**Re: Raising Cane's South Half of 2004 Wyoming Blvd NE
Erosion and Sediment Control Plan
Engineer's Stamp Date 8/9/2022 (H20E003D)**

Based upon the information provided in your submittal received on 9/1/22, the above referenced ESC Plan can't be approved until the following comments have been addressed.

Sheet Title:  
**EROSION CONTROL PLAN**

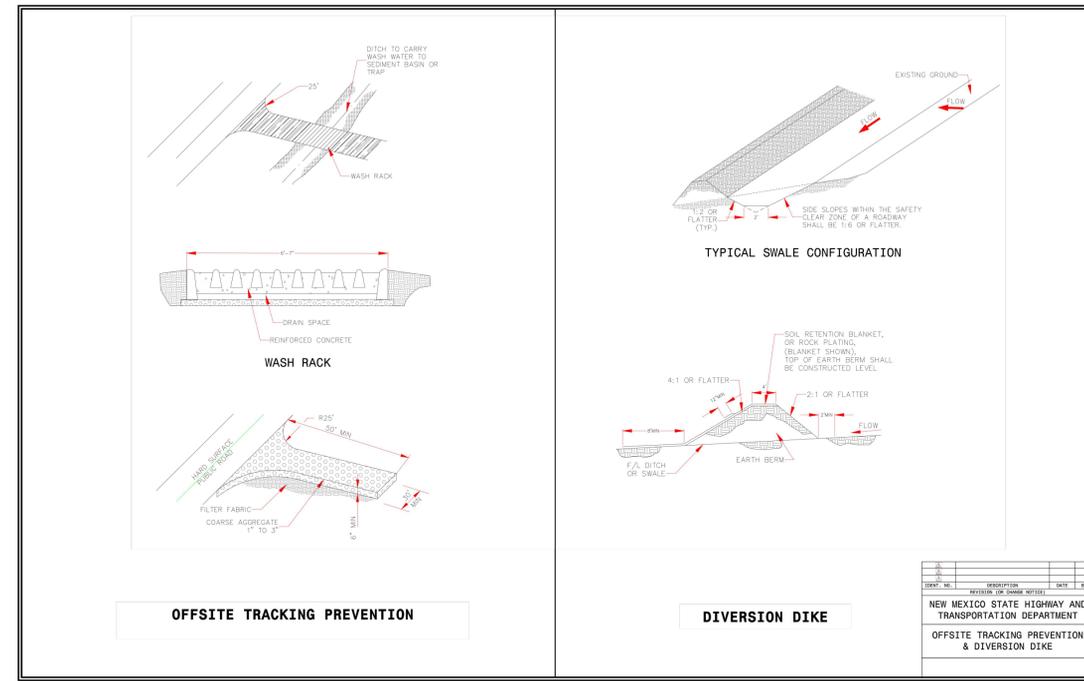
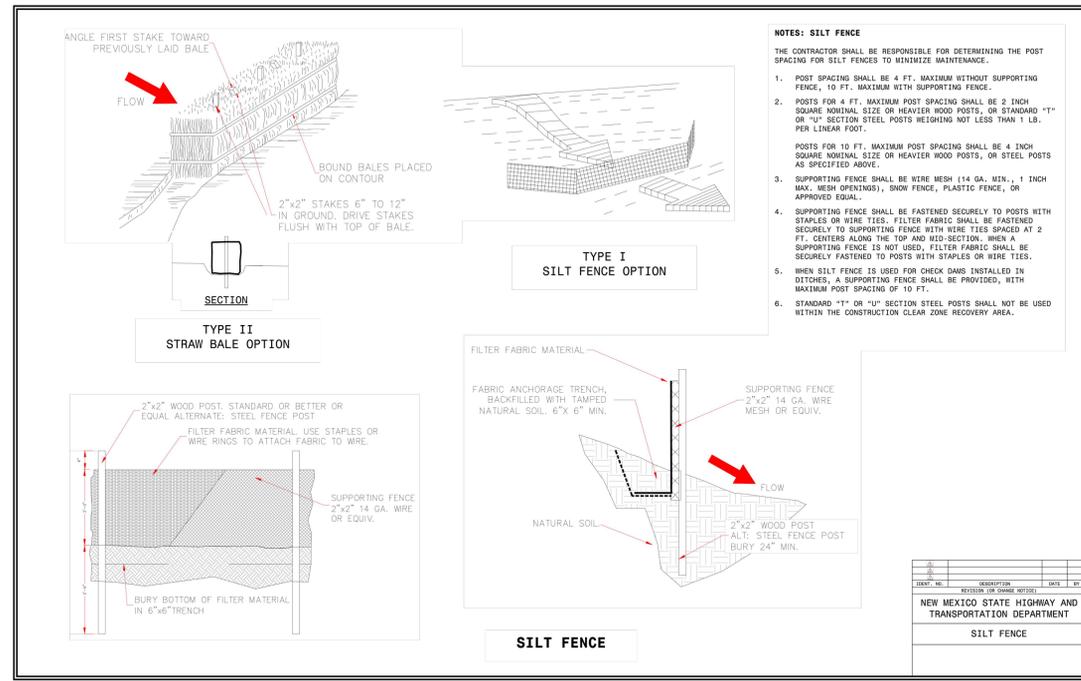
1. The property owner's NOI is required for the south half of the site. The ESC Plan can't be approved for Grading or Demolition Permit until the property owner's NOI has been reviewed and approved by City Stormwater Quality per Albuquerque Code § 14-5-2-11(a). County records show WFC Wyoming NM, LLC owns this 2 acre Parcel 5-A of the Wyoming Mall. So either provide their NOI or a separate NOI for a new owner along with a lease, deed, or easement showing the new owner's property rights.
2. Silt fence must extend around the entire area of land disturbing activities.
3. Update the engineer's stamp date each time the plan is changed.
